Planning Inspectorate reference: EN070008

**APPLICATION BY CHRYSAOR PRODUCTION (UK) LIMITED (THE APPLICANT) FOR A DEVELOPMENT CONSENT ORDER FOR THE VIKING CCS PIPELINE (EN070008).**

**THE VIKING CCS PIPELINE. EN070008 – APPLICATION FOR CHANGE REQUEST**

TITLE: THE THEDDLETHORPE FACILITY PLOT PLAN

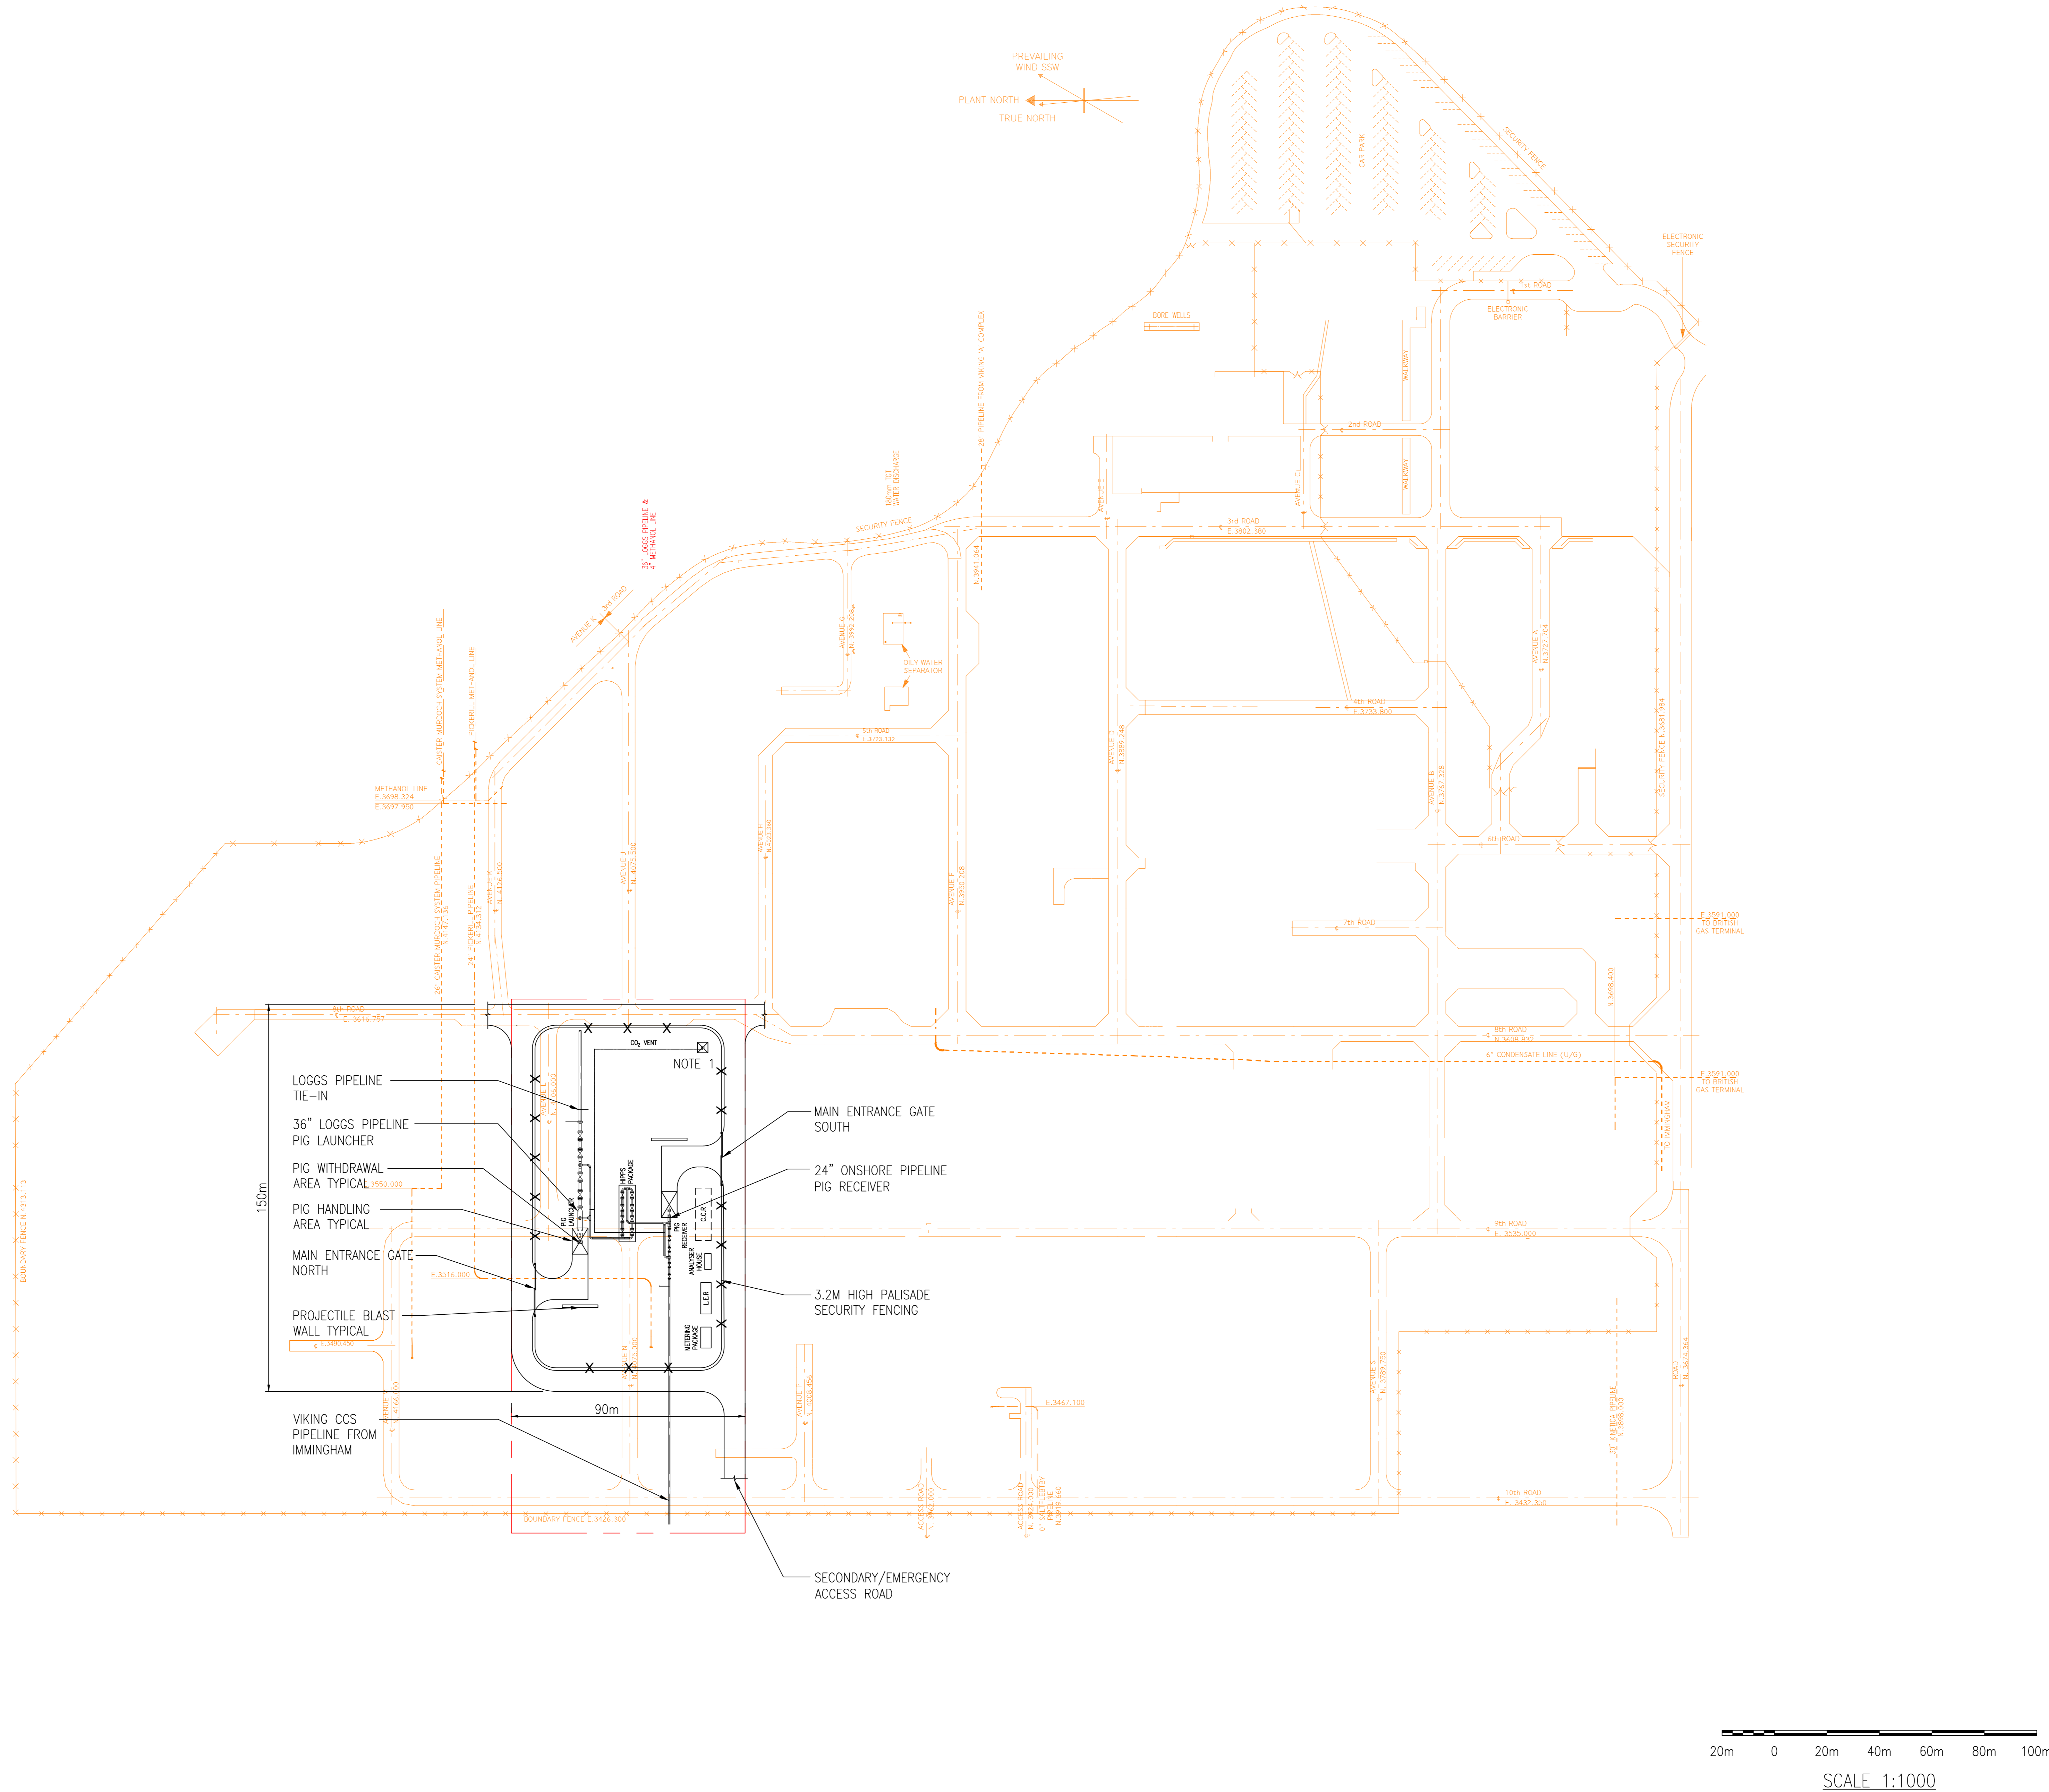
**Change 5:** Removal of Theddlethorpe Facility Option 2 from the Application.

The Applicant and NGT have now reached agreement on the terms of a voluntary agreement, with engrossed versions of those agreements now going through the final corporate approval processes of the respective organisations. As a result of this progress, the Applicant is now confident that Option 2 is no longer required and the Applicant is submitting a change request for this to be removed from the Proposed Development. As such the application document titled: Theddlethorpe Facilities Option 2, Plot Plan, Routing and Elevations [APP-021] is no longer relevant and can be withdrawn.

**Change 6:** Removal and modification of the Order Limits around the Theddlethorpe Facility Option 1 and Option 2.

Following continued engagement with NGT and Mablethorpe Flexible Generation Limited and as part of the voluntary agreement that would allow the use of the TGT Site for the Theddlethorpe Facility, a number of minor amendments to the Order Limits are required.

Drawing title
**LOUTH ROAD
BLOCK VALVE STATION
(BVS3)
Regulation 5.2 (o)
Application Document Reference 4.16
(Sheet 1 of 1)**

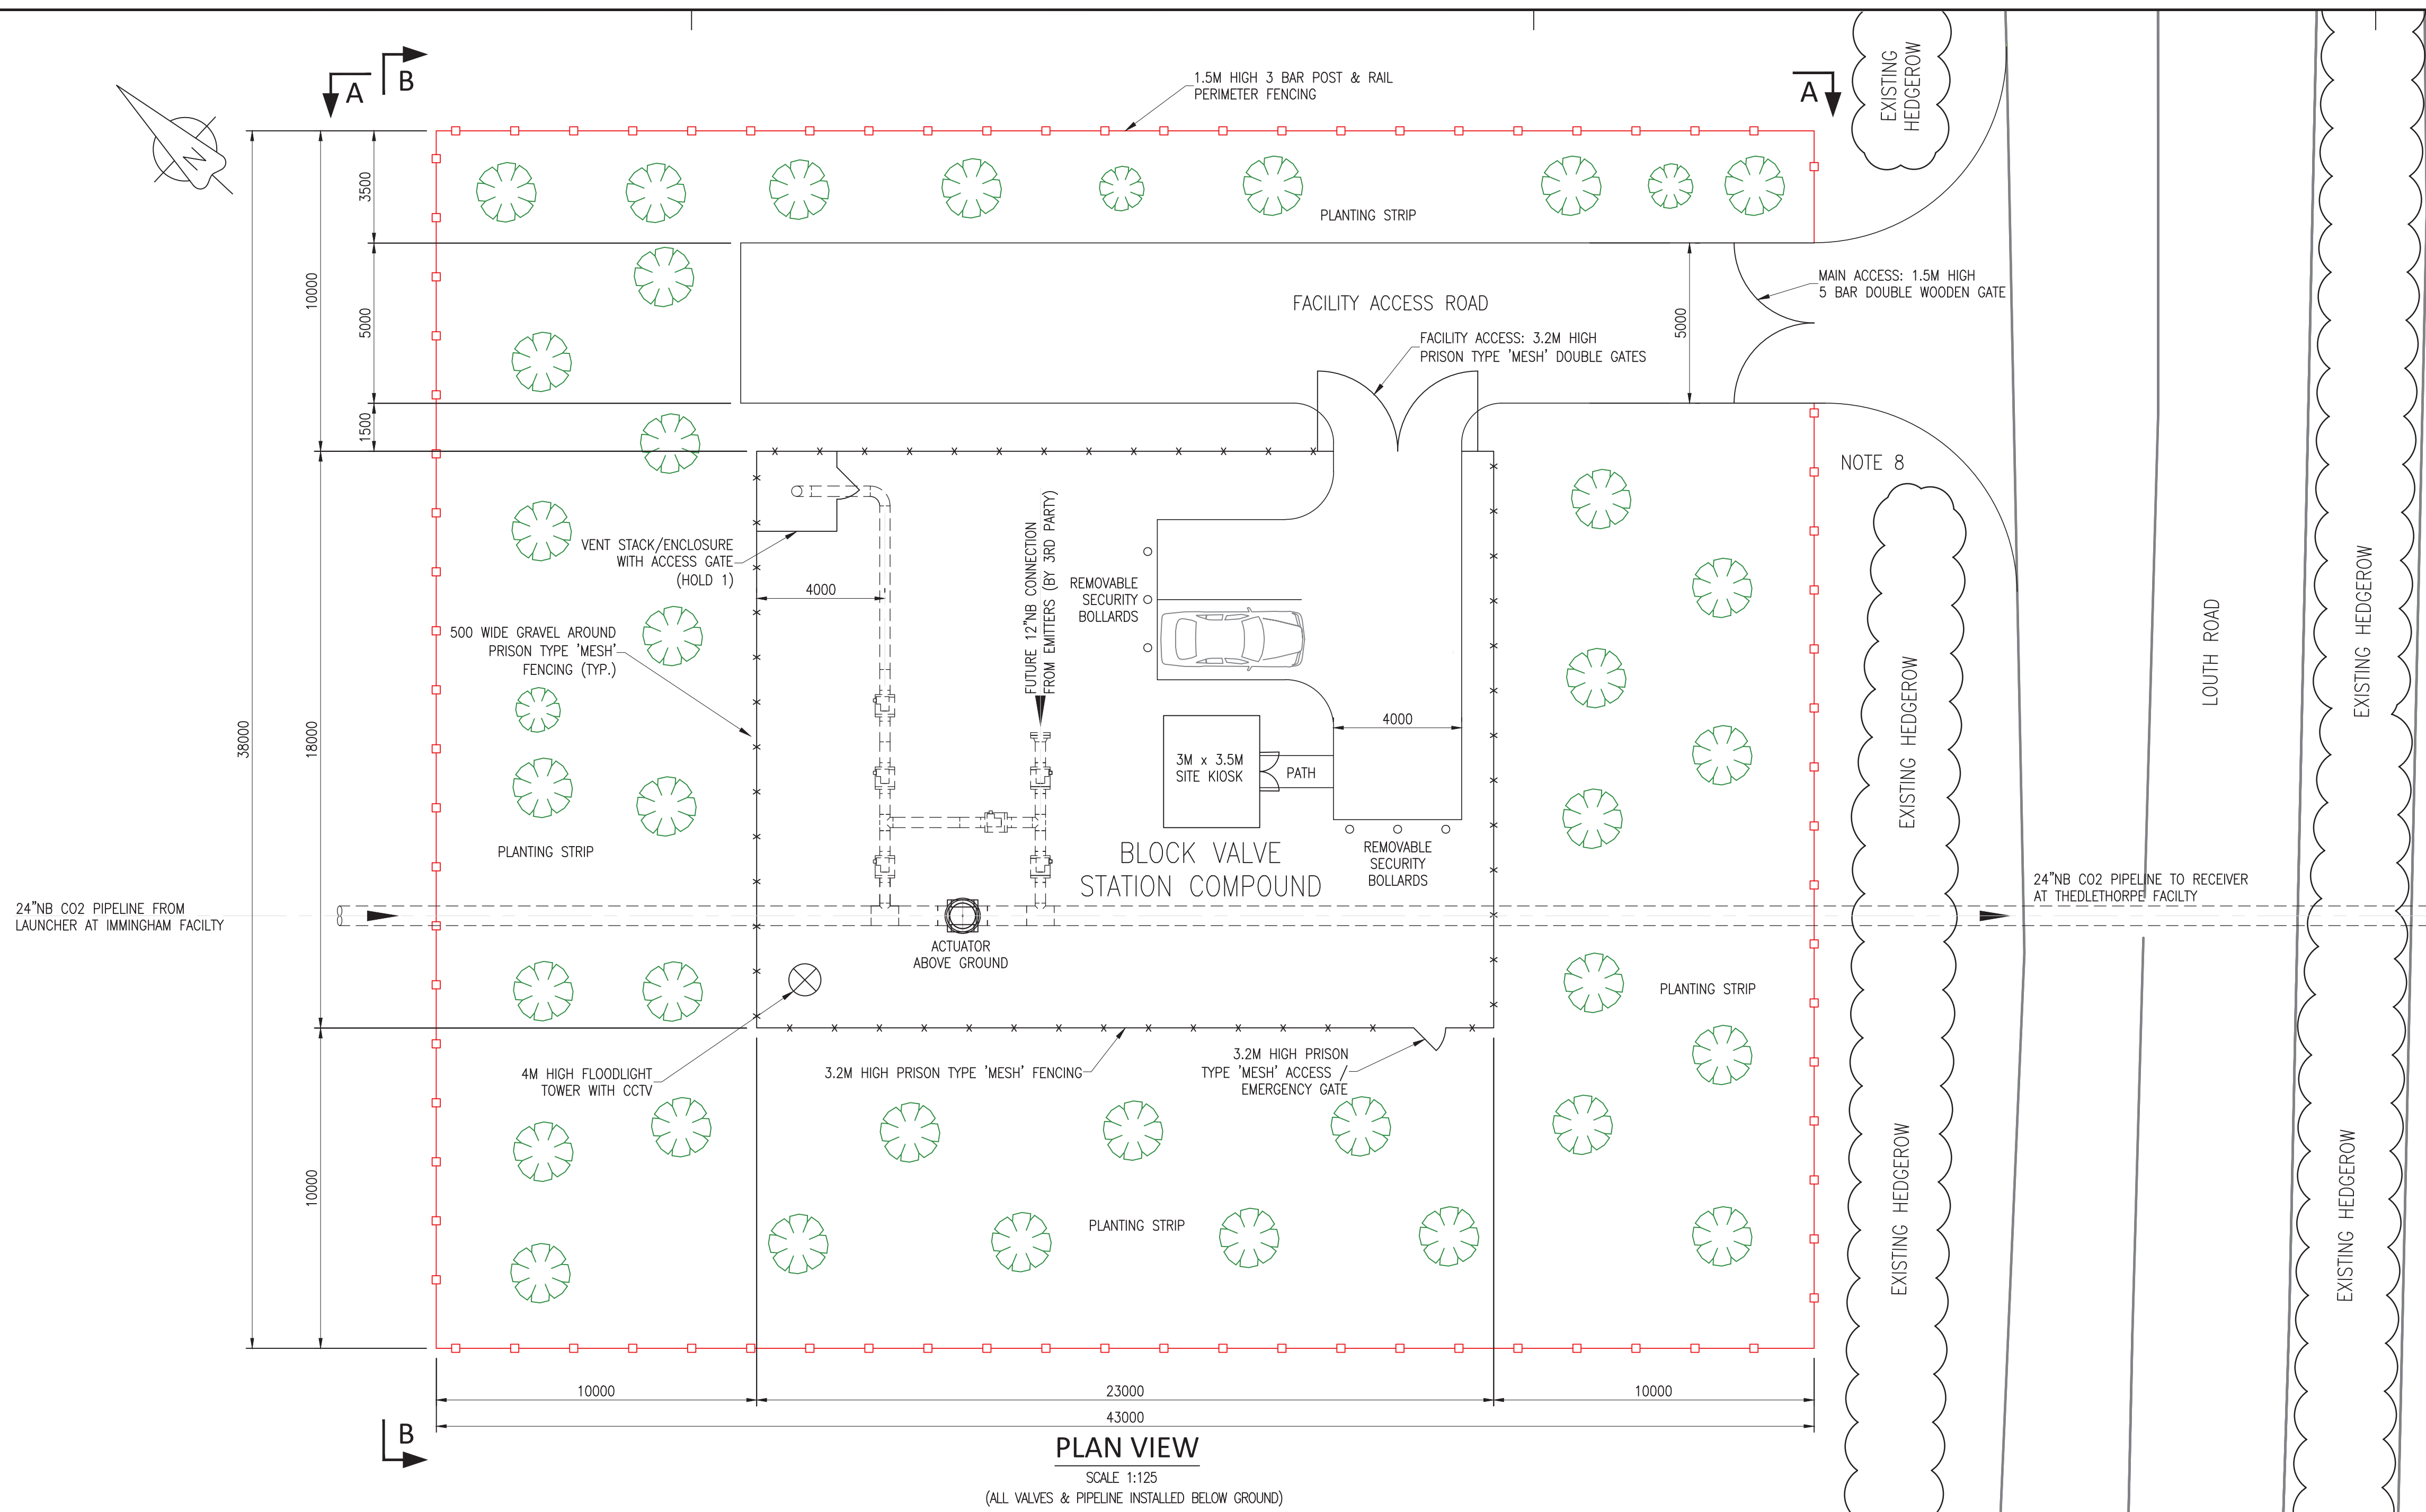
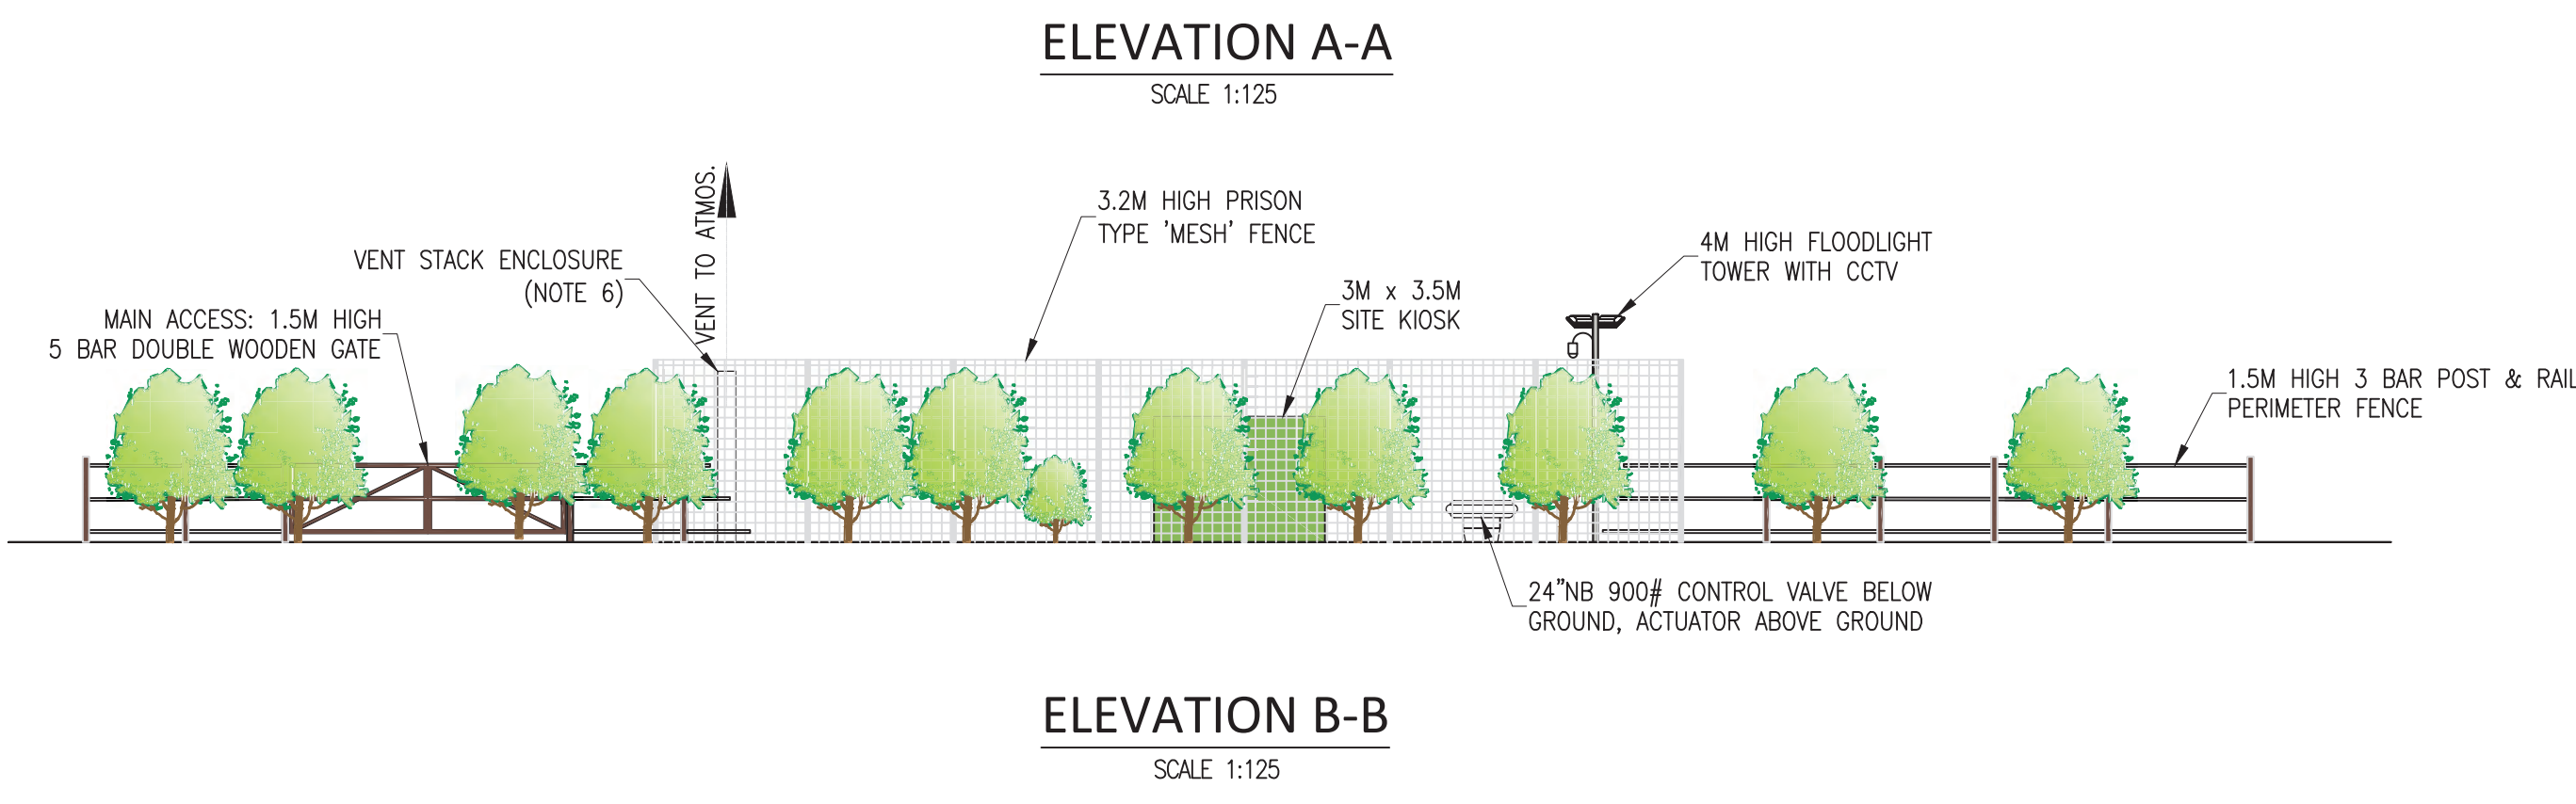
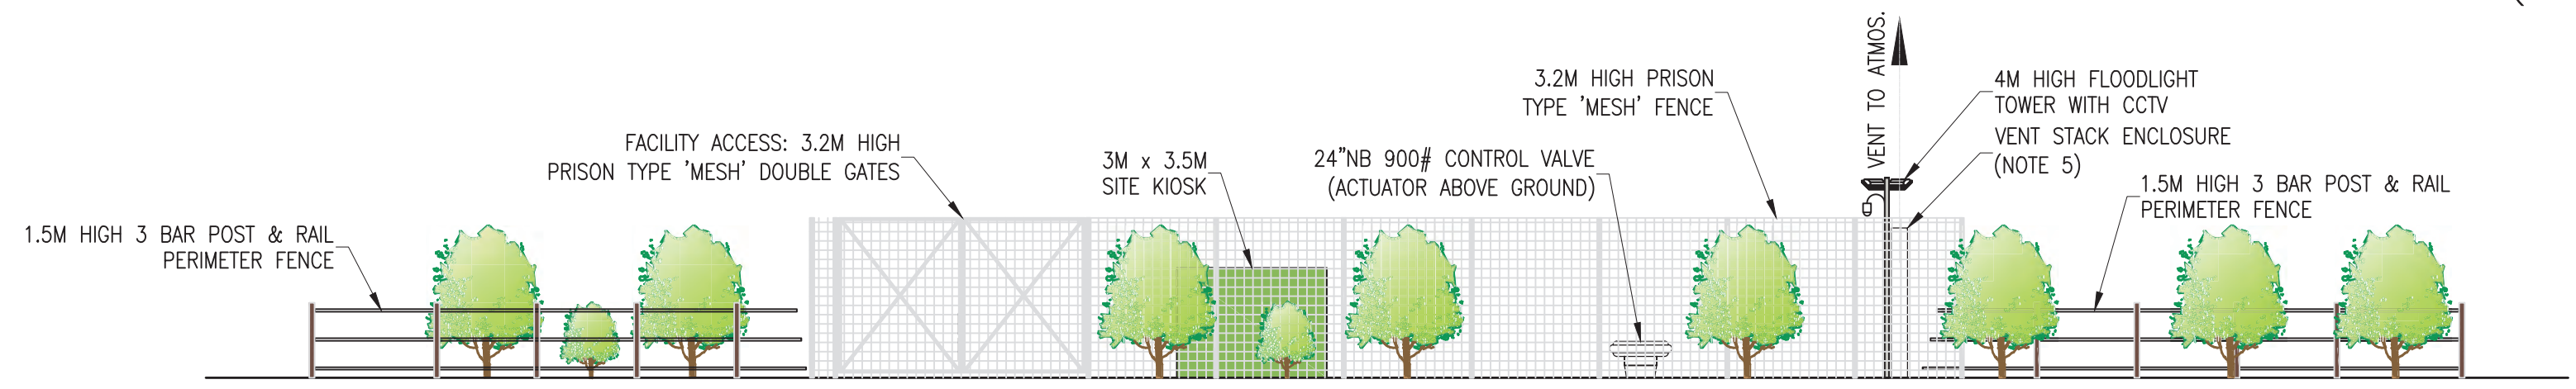
**Change 3:** Relocate Block Valve Station 3 (Louth Road BVS) to the south of Louth Road near Alvingham within the existing Order Limits.

Following submission of the application and discussions with the landowner, it was requested that Louth Road BVS be moved to the opposite side, to the south of Louth Road. The Applicant understands that the proposed location will have a lower impact on the landowner's agricultural operations.
